Gatwick Airport Northern Runway Project

Statement of Common Ground Between Gatwick Airport Limited and Horsham District Council – Clean Version

VERSION: 3.0

DATE: AUGUST 2024

Diagram 3.3.9: Model performance before and after adjustment, London zone

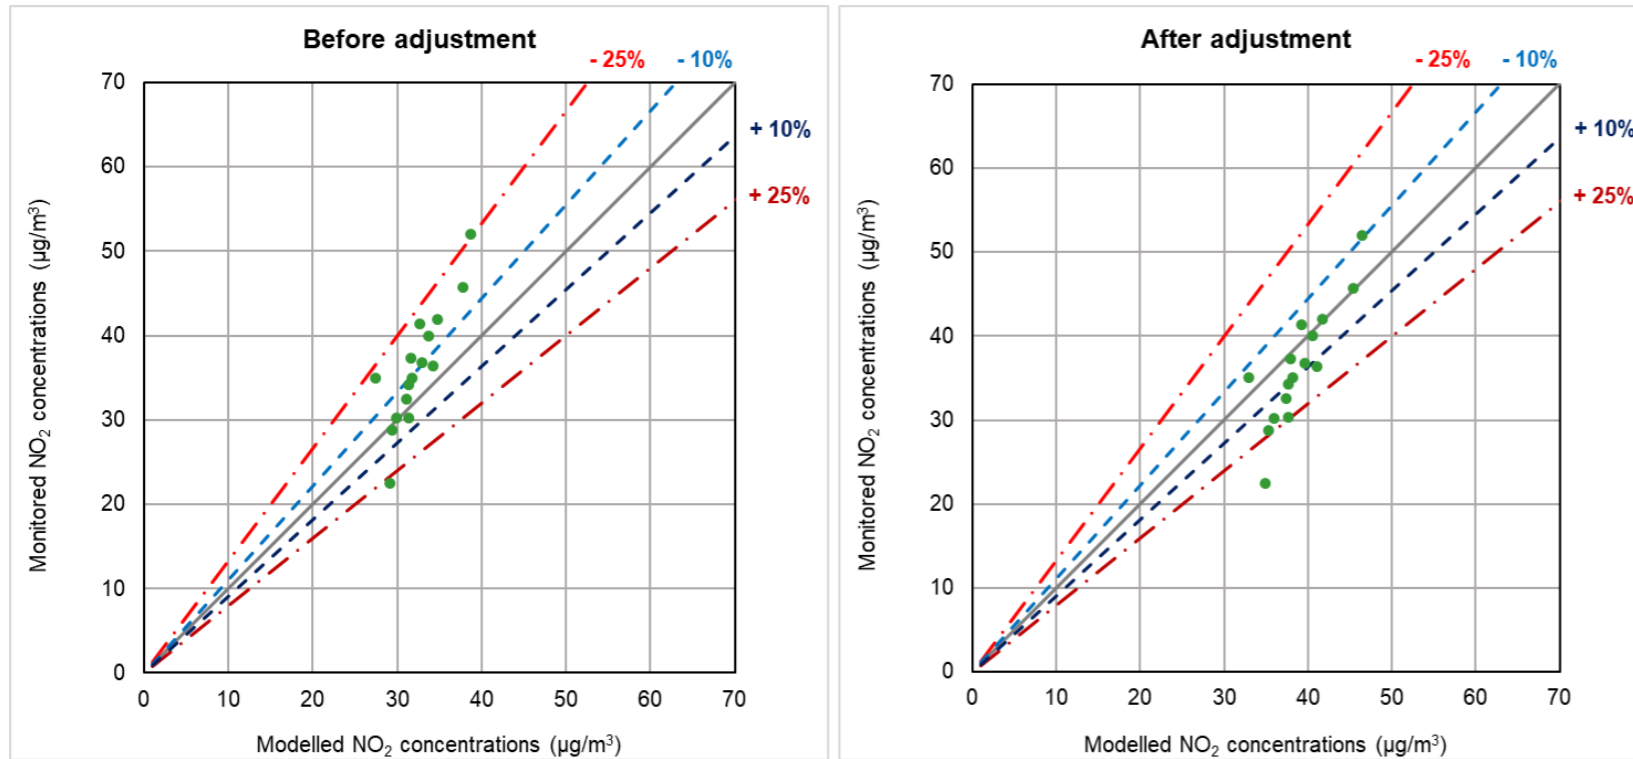
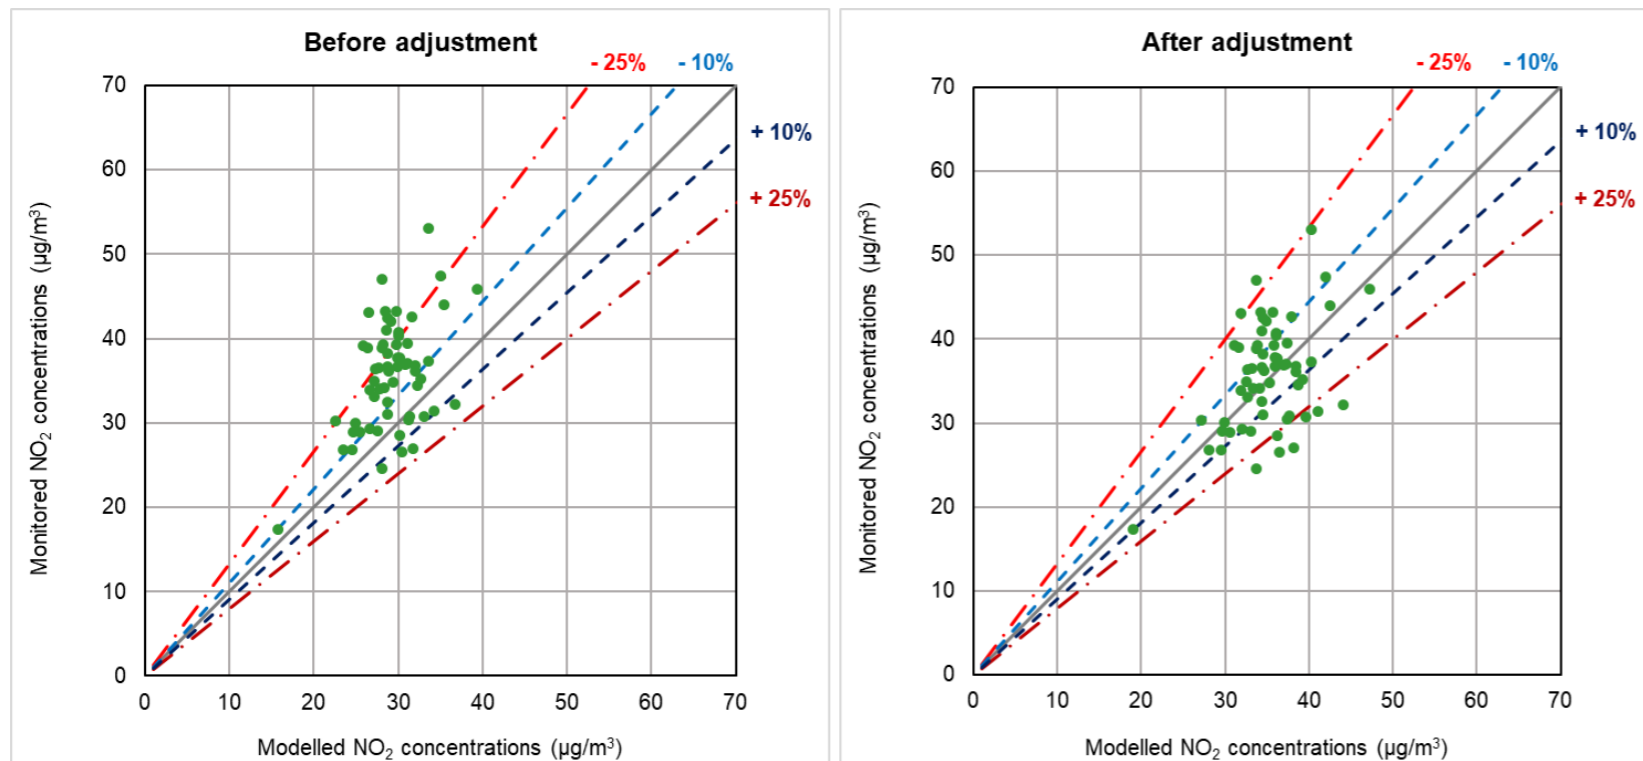
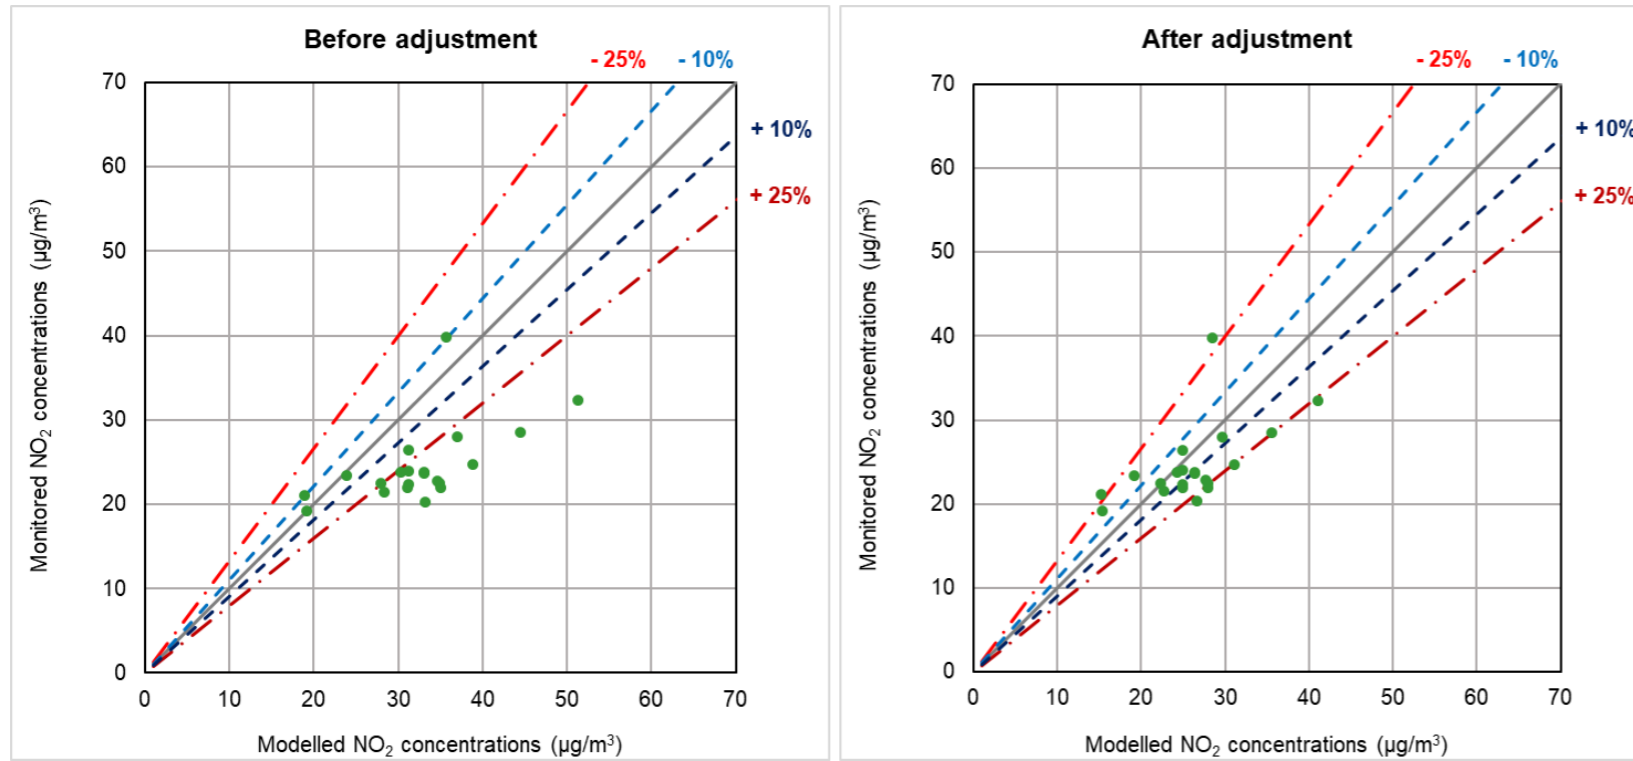
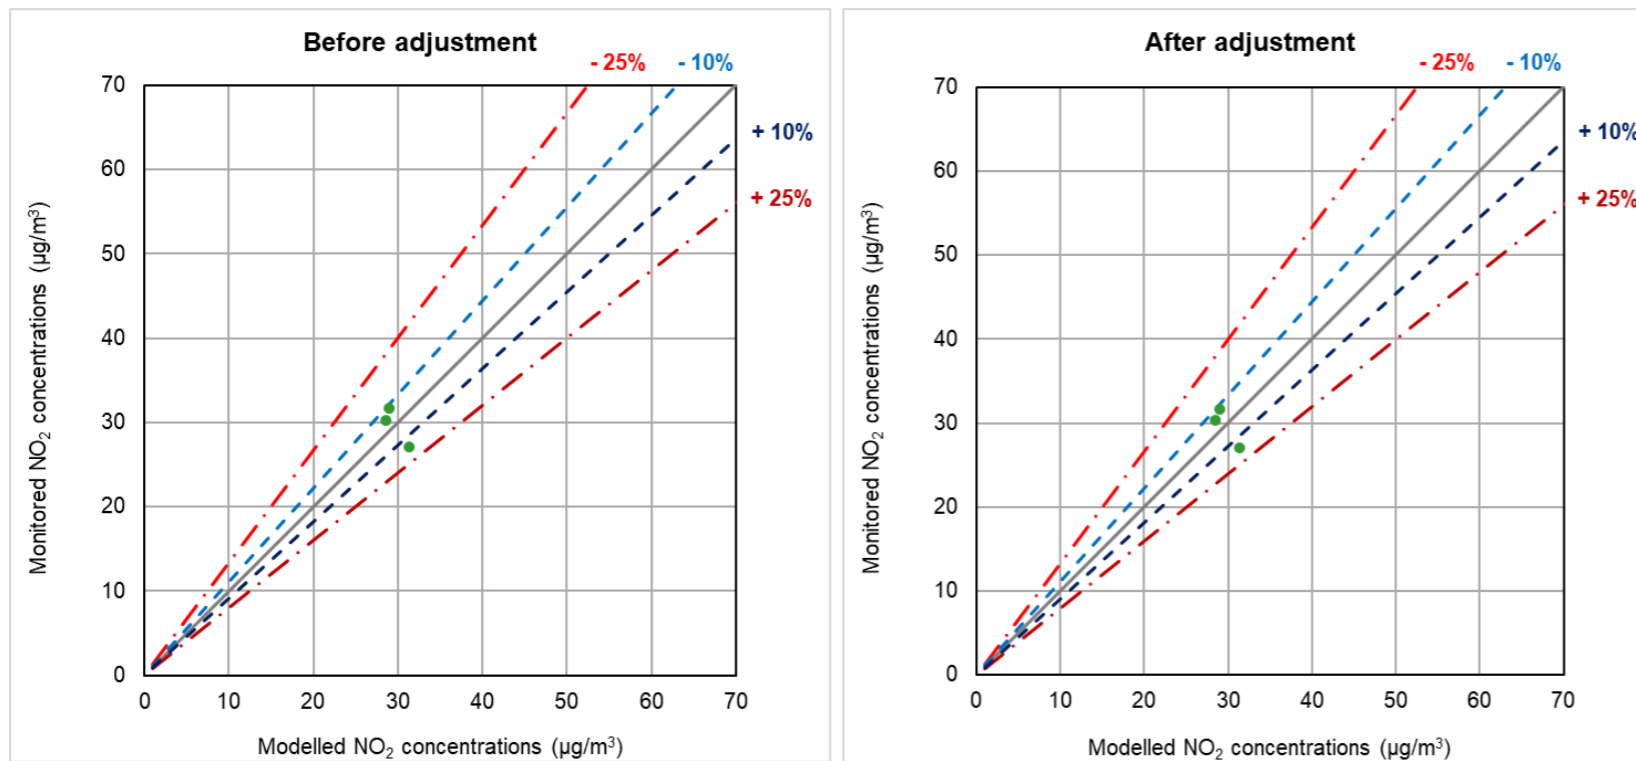
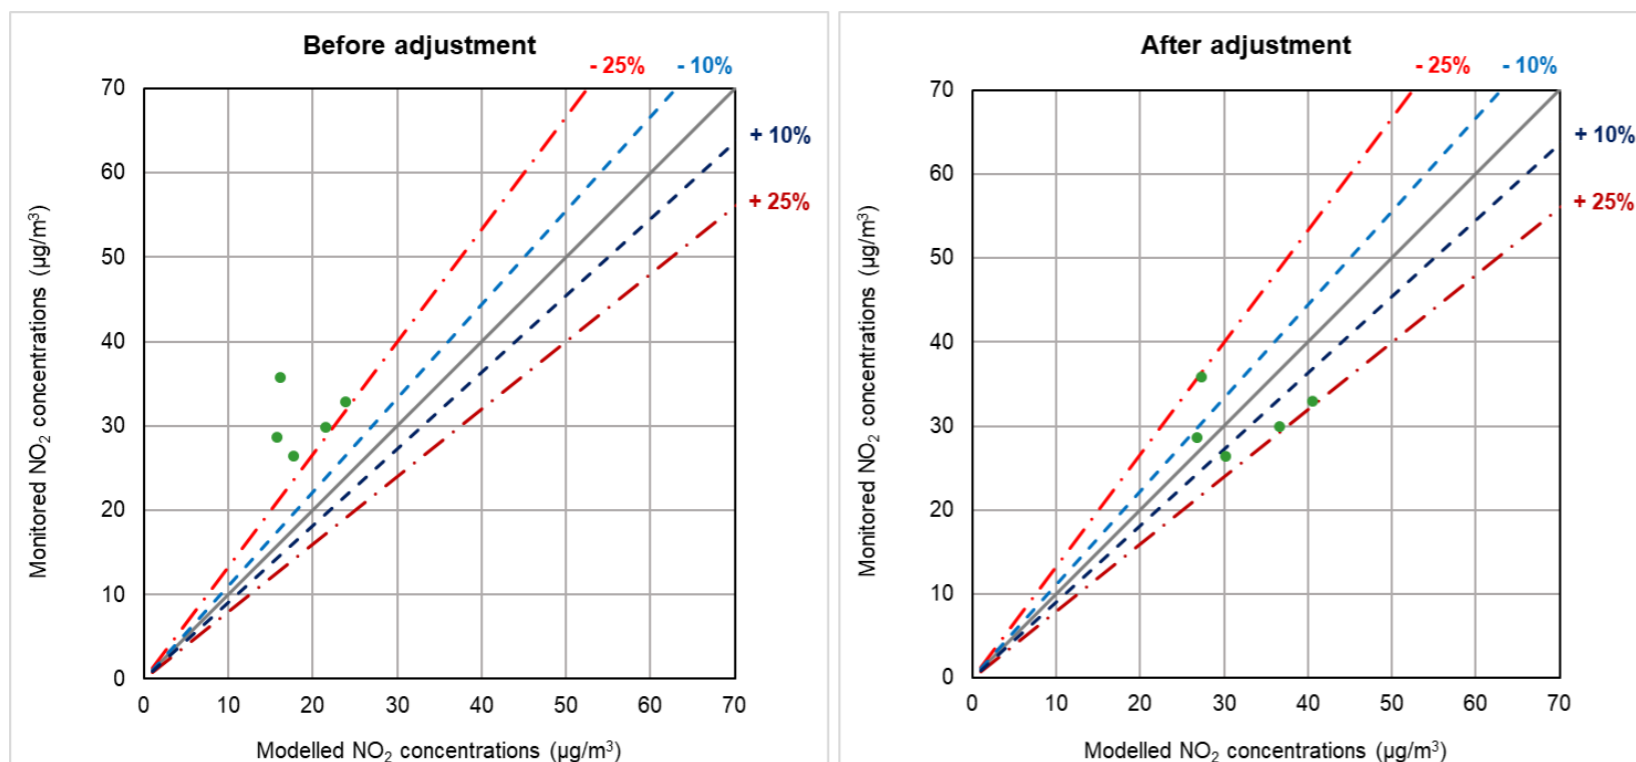
<p>2.2.2.3</p>	<p>Model Set Up and Methodology</p>	<p>Regarding model verification, Appendix 13.6.1: Air Quality Data and Model verification is missing details on how model verification factors for the selected zones were established. Details are required of the initial verification including Monitored Road NOx Contribution versus Unverified Modelled Road NOx, which monitoring sites were used, and which were removed from the verification process. To facilitate the scrutiny of the model set up and any assumptions used, it is requested that a complete set of input files be shared for 2018 (Base Year) and 2029 (nearest future year). In addition, Operational and Construction impacts for 2029 should be modelled jointly as one scenario, in order to enable the evaluation of all impacts associated with the development.</p> <p>Updated position (Deadline 1): We welcome the provision of model files. There are a few residual queries from this review and the review of the verification appendix. These include: further details on why so many sites were excluded from the verification and how we identify which receptors received which verification factor. Confirmation on why a later 2022 baseline year was not used too.</p> <p>It is welcomed that GAL propose to provide further information on modelling scenarios at the next air quality TWG. This matter will remain under discussion until this TWG has been held.</p> <p>Version 3 Deadline 5 Response Gatwick Airport Limited (GAL) sets of in paragraph 3.7.7 of their Response to Deadline 3 Submissions [REP4-031] that the air quality matters submitted by the Joint Local Authorities at Deadline 3 (Appendix A) [REP3-117] will be responded to by Deadline 5. This Appendix of air quality queries prepared by AECOM included a wide range of technical</p>	<p>Full details of the model verification process are included in Section 3 within the ES Appendix 13.6.1. Table 3.2.2 provides a list of all sites excluded along with justification and Table 3.3.2 provides a comparison between modelled and monitored NO_x and NO₂ concentrations.</p> <p>The verification methodology was agreed with local councils at the modelling methodology workshop in November 2022. Model files and results were provided to the TWG via email 18th August 2023.</p> <p>Traffic modelling has been undertaken for two construction scenarios, airfield construction and surface access (highways) construction. Further detail is contained in Report 7.4 of the Transport Assessment. The construction scenarios assume the peak construction traffic flows applied to the first year of airfield (2024) and surface access (2029) construction which is a conservative assumption since emissions and background concentrations are anticipated to improve in future years.</p> <p>As set out in paragraph 13.5.53 of ES Chapter 13: Air Quality, the 2029 surface access construction scenario represents years 2029-2032, during which there will be an overlap with the operation of the Project. The 2029 surface access construction scenario is a combined scenario considering the contribution from both construction and operational traffic over this period to represent a realistic worst case assessment.</p> <p>Updated position (Deadline 1): A verification figure has been provided at Deadline 1 which shows the factor applied to each</p>	<p>ES Appendix 13.6.1 Air quality Data and Model Verification [APP-159]</p> <p>ES Chapter 13 Air Quality [APP-038]</p> <p>ES Report 7.4 Transport Assessment [AS-079]</p> <p>Appendix A of the Supporting Air Quality Technical Notes to the SoCGs [REP1-050]</p> <p>Appendix D of the Supporting Air Quality Technical Notes to the SoCGs [REP1-050]</p> <p>Appendix A: Response to West Sussex Joint Local Authorities – Air Quality to The</p>	<p>Agreed</p>

<p>matters. Without a response from GAL further progress cannot be made. It is anticipated that further progress can be made before the next Examination Deadline.</p>	<p>receptor, contained in Appendix A of the Supporting Air Quality Technical Notes to the SoCGs (Doc Ref. 10.4).</p> <p>GAL has also set out the model scenarios and provide that summary at Deadline 1, within Appendix D of the Supporting Air Quality Technical Notes to the SoCGs (Doc Ref. 10.4).</p> <p>Updated position (April 2024): The Applicant notes that the JLAs have provided a submission on air quality at Deadline 3. The Applicant will review this submission and respond accordingly.</p> <p>Updated position (Deadline 5): The Applicant has provided a response to the air quality matter submitted by the JLAs at Appendix A: Response to West Sussex Joint Local Authorities – Air Quality to The Applicant’s Response to Deadline 4 Submissions (Doc Ref. 10.38). The Applicant will respond at Deadline 6 to the JLAs’ review submitted at Deadline 4 [REP4-053].</p> <p>Updated Position (July 2024): This matter can be marked as ‘agreed’ following consultation with AECOM on behalf of the local authorities on the technical queries set out at Deadline 5 [REP5-073].</p>	<p>Applicant’s Response to Deadline 4 Submissions [REP5-073]</p>
